TfNSW reference: REN25/00096/001

Your reference: SSD-63207219

TfNSW Response- SSD-63207219 – Kingswood BESS –Response to Submissions referral

TfNSW Response- SSD-63207219 – Kingswood BESS – Response to Submissions referral

Figure 3-2: OSOM route proposed in the TIA (Update) (October 2025) (Source: NVHR Route Planner Tool) – Option 1

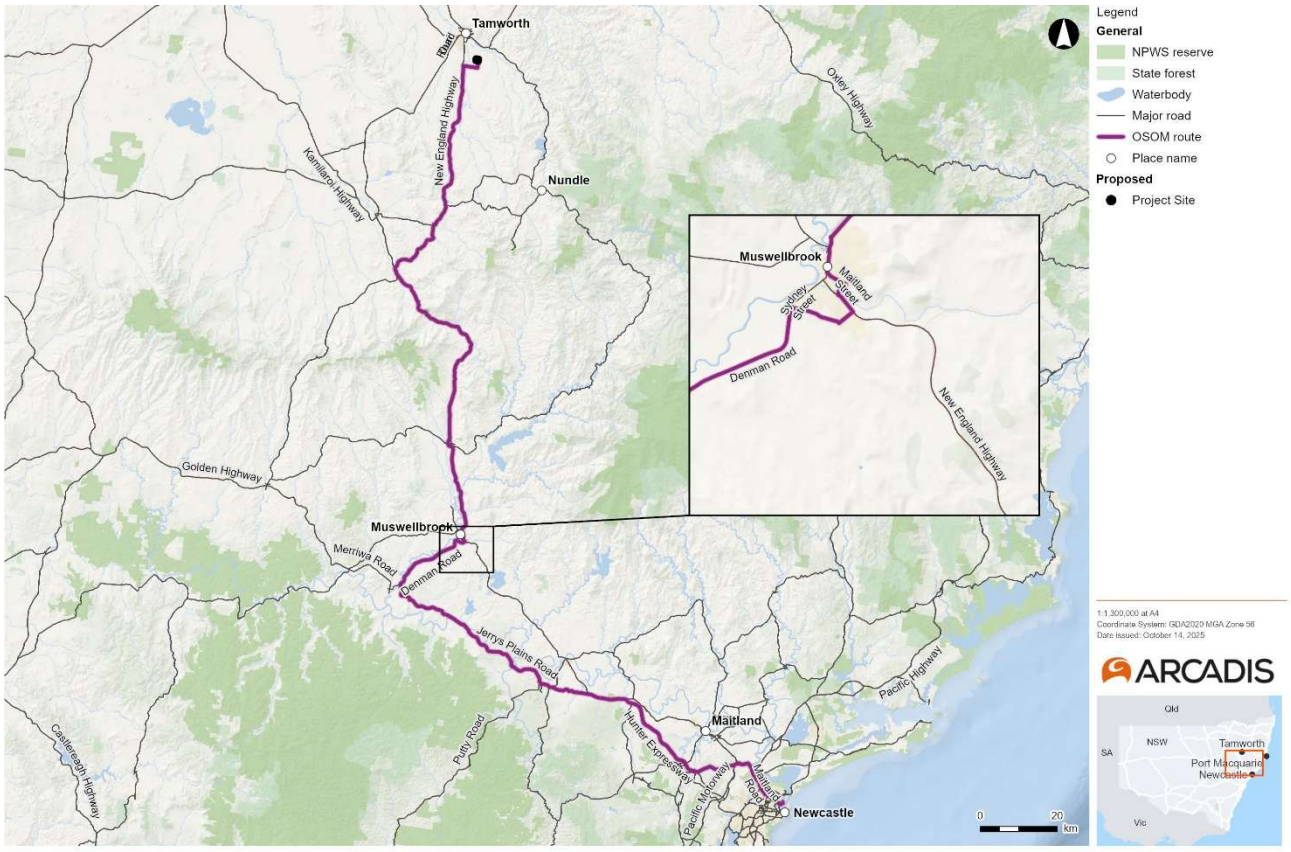
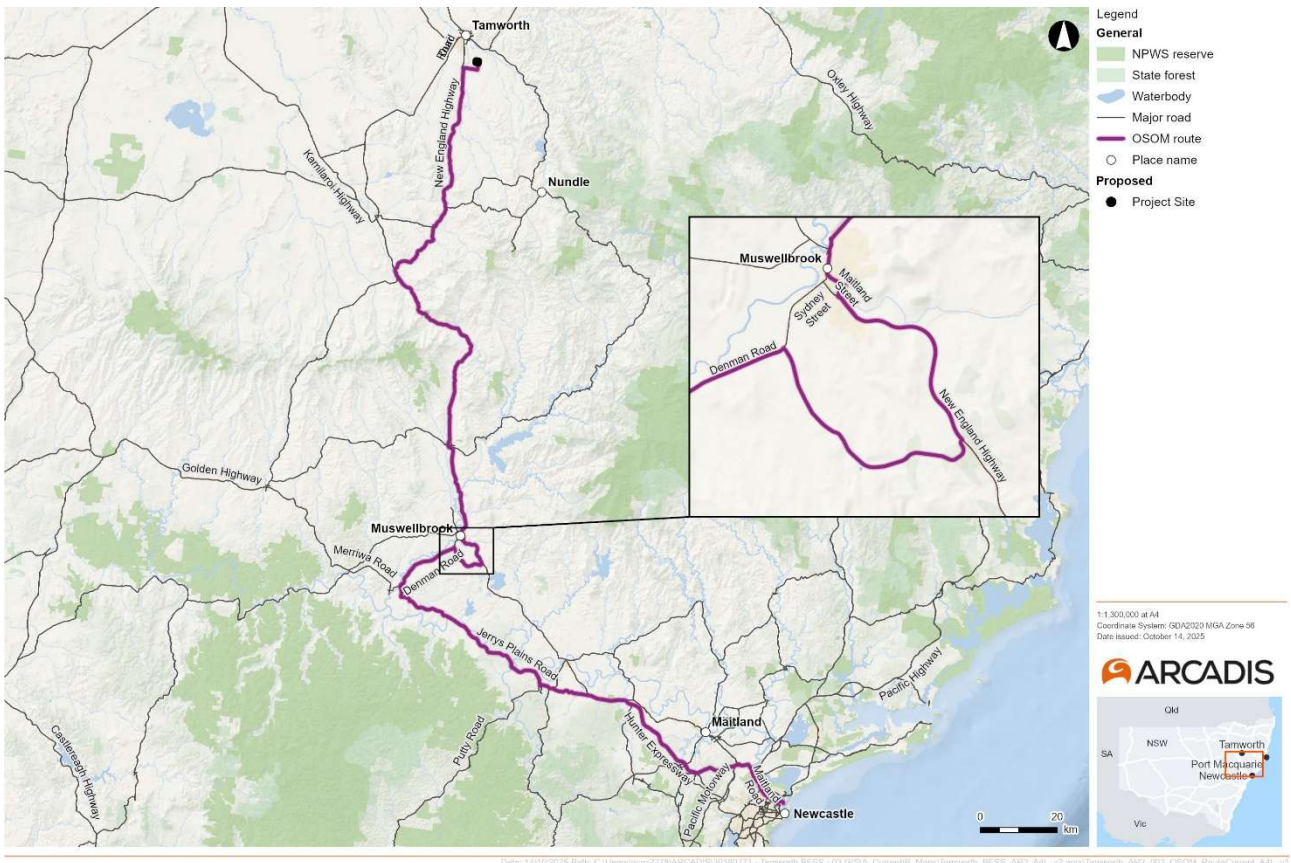
2. The provided route assessment is required to be reviewed and updated with further detail to address the following:
- a) Point 2 of the previous letter requested bridge assessments to be undertaken. The TIA advises that the bridge assessments will be completed post-approval as part of preparing the Traffic Management Plan.

- b) Section 3.5.1.2 has been included within the revised TIA to address point 5(b) of TfNSW previous additional information request. Section 3.5.1.2 advises that the size and number of OSOM vehicles will be confirmed during the construction phase and included in the Construction Traffic Management Plan. TfNSW advises that the dimensions of high-risk OSOM-laden loads (heights, lengths, and widths) and weights should be identified, and a route analysis should be completed before determining the project.

- c) The route assessment will consider current projects along the road network, including the Newcastle Inner City Bypass (which is required to be used to avoid the Hexham Straight works for high-risk OSOM up to a height of 5.25m) and Singleton Bypass project at the New England Highway, resulting in a height restriction of 5.4m.
- d) The swept path diagrams provided demonstrate the combination mounts for the garden section of the Market Street roundabout. The section of the roundabout that will be mounted is a non-trafficable portion. An assessment and strategic concept design will be prepared to identify the pavement and modifications required for the garden section of the roundabout to accommodate the proposed high-risk OSOM-laden loads. Previously raised this issue within point 5(d) of TfNSW response to Kingswood BESS EIS.

Figure 3-3: Heavy vehicle access route via Whitehouse Lane, Ascot-Calala Road and Burgmanns Lane

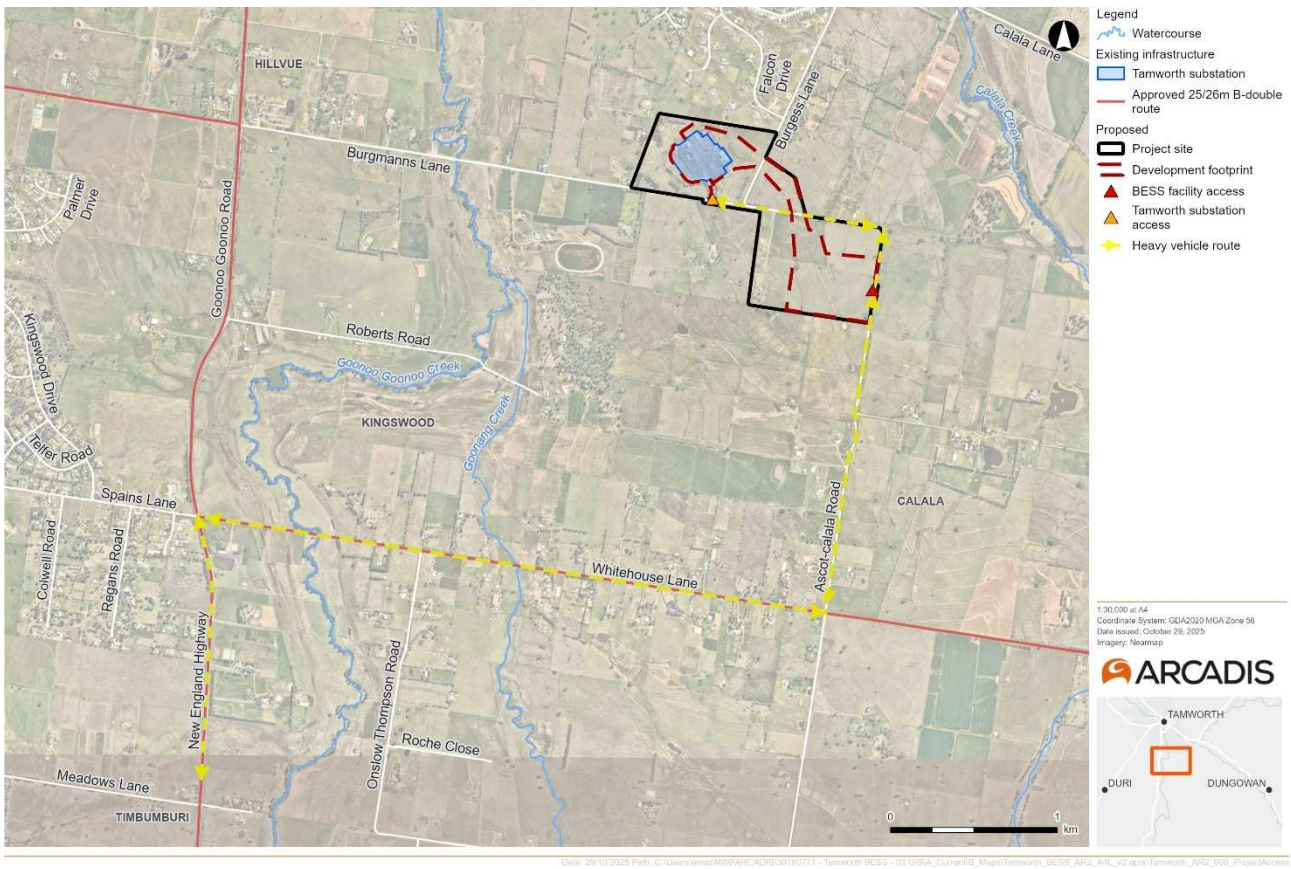
- 3. TfNSW previously requested a swept path analysis of the Burgmanns Lane/New England Highway intersection within point 1(d) of TfNSW's response to the EIS for this project. The revised TIA identifies that the rationale for not providing swept paths for concurrently turning the design heavy vehicle at the New England Highway/Burgmanns Lane intersection is that the project only proposes to use this intersection for light vehicles. TfNSW will require a condition and enforceable traffic management measures stipulated within the traffic management plan condition to enforce the prohibition of using the intersection for the project's heavy vehicle construction traffic.

Figure 1 – New England Highway / Burgmanns Lane upgrade

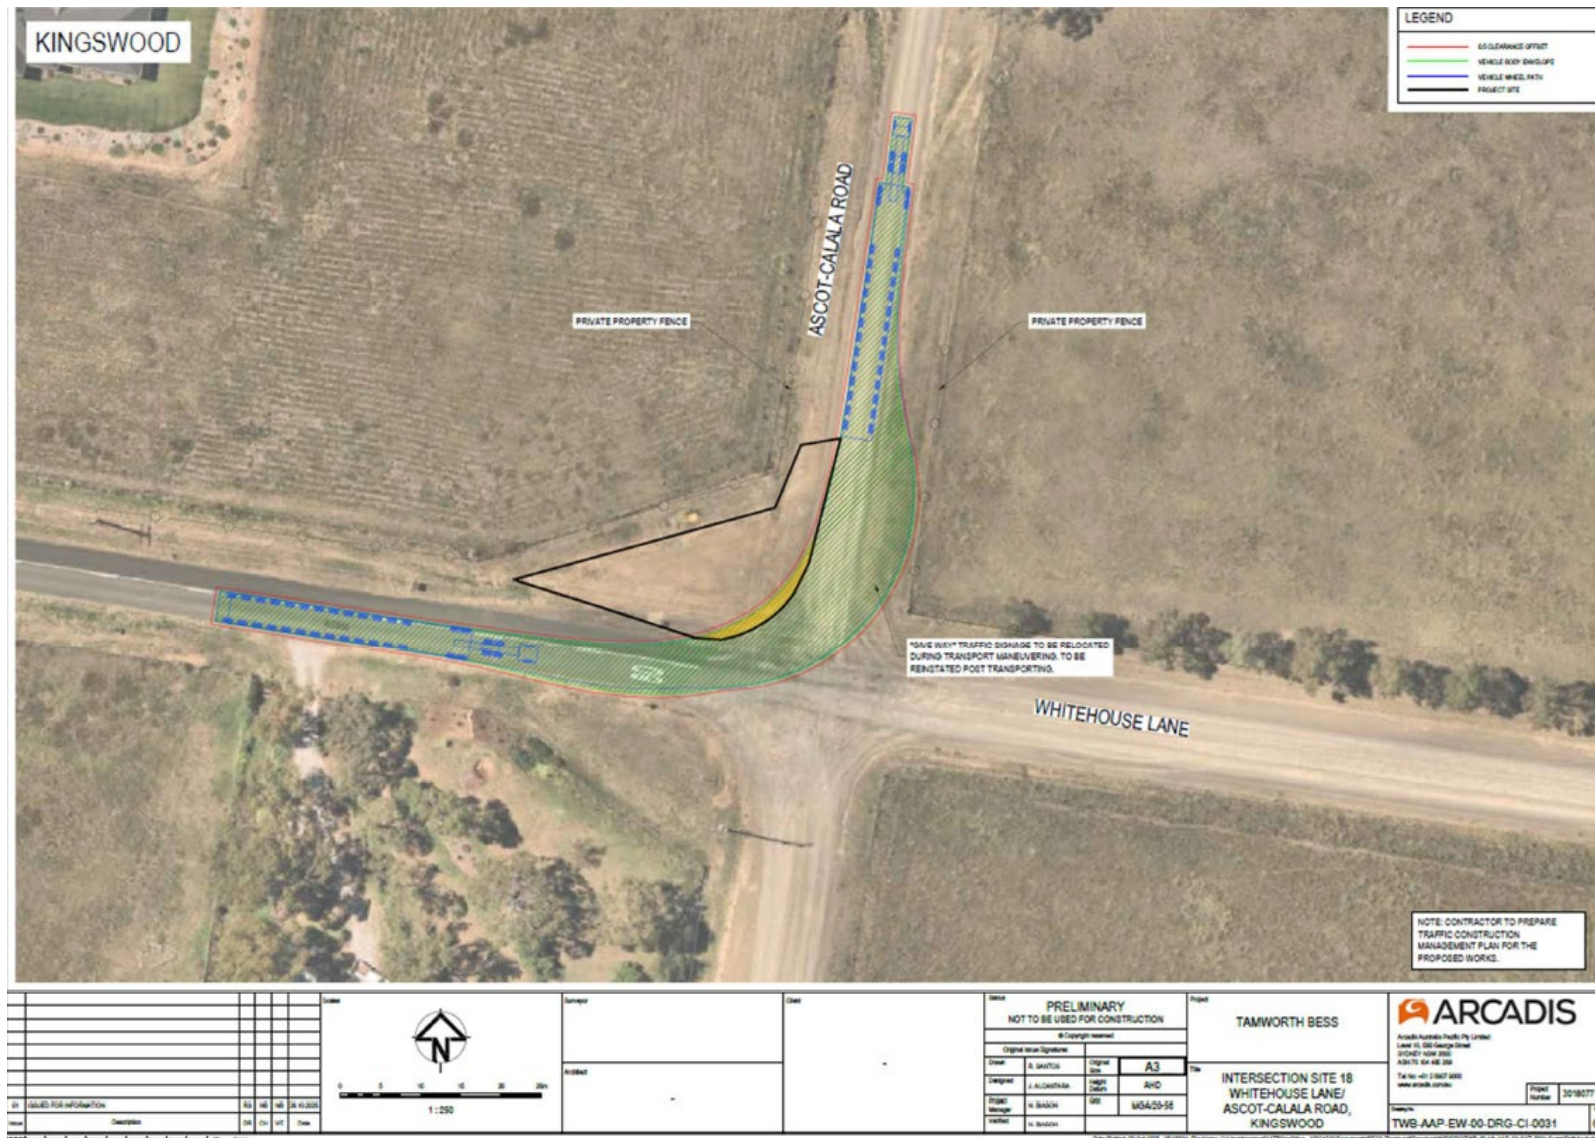
1. The revised TIA is still required to assess the suitability of the existing intersection treatments for both traffic at Burgmanns Lane/New England Highway intersections and Whitehouse Lane/New England Highway, raised previously within point 1(a). Points 1(a) and (b) below provide clarification on the additional information that TfNSW is requesting:

- a) TfNSW acknowledges the updated turn warrants assessment and includes the worst-case scenario within section 3.2 of the revised TIA for both the Burgmanns Lane/New England Highway and the Whitehouse Lane/New England Highway intersection.
However, based on the outcome of this assessment within s3.2, the conclusion is that a CHR/AUL is required to accommodate project traffic and that both intersections have existing CHR/AUL intersection treatments.
TfNSW have reviewed the existing intersection treatments and identified the following:

- New England Highway/Whitehouse Lane- AUL/CHR(S), and
 - New England Highway/Burgmanns Lane- CHR/AUL(S).On this basis, TfNSW requests that the proponent reviews the existing intersection treatments to assess whether they conform to an AUL/CHR intersection treatment type.

- b) If the intersection treatments do not comply with an AUL/CHR intersection treatment type, then the following options will need to be considered to address the difference between the existing and required intersection treatments at both intersections with the state road network:

- Provide a strategic concept design to increase the length of the CHR(S) to a compliant CHR for the New England Highway/Whitehouse Lane intersection and provide a strategic concept design to increase the length of the AUL(S) to a compliant AUL for the left turn treatment at New England Highway/Burgmann's Lane.
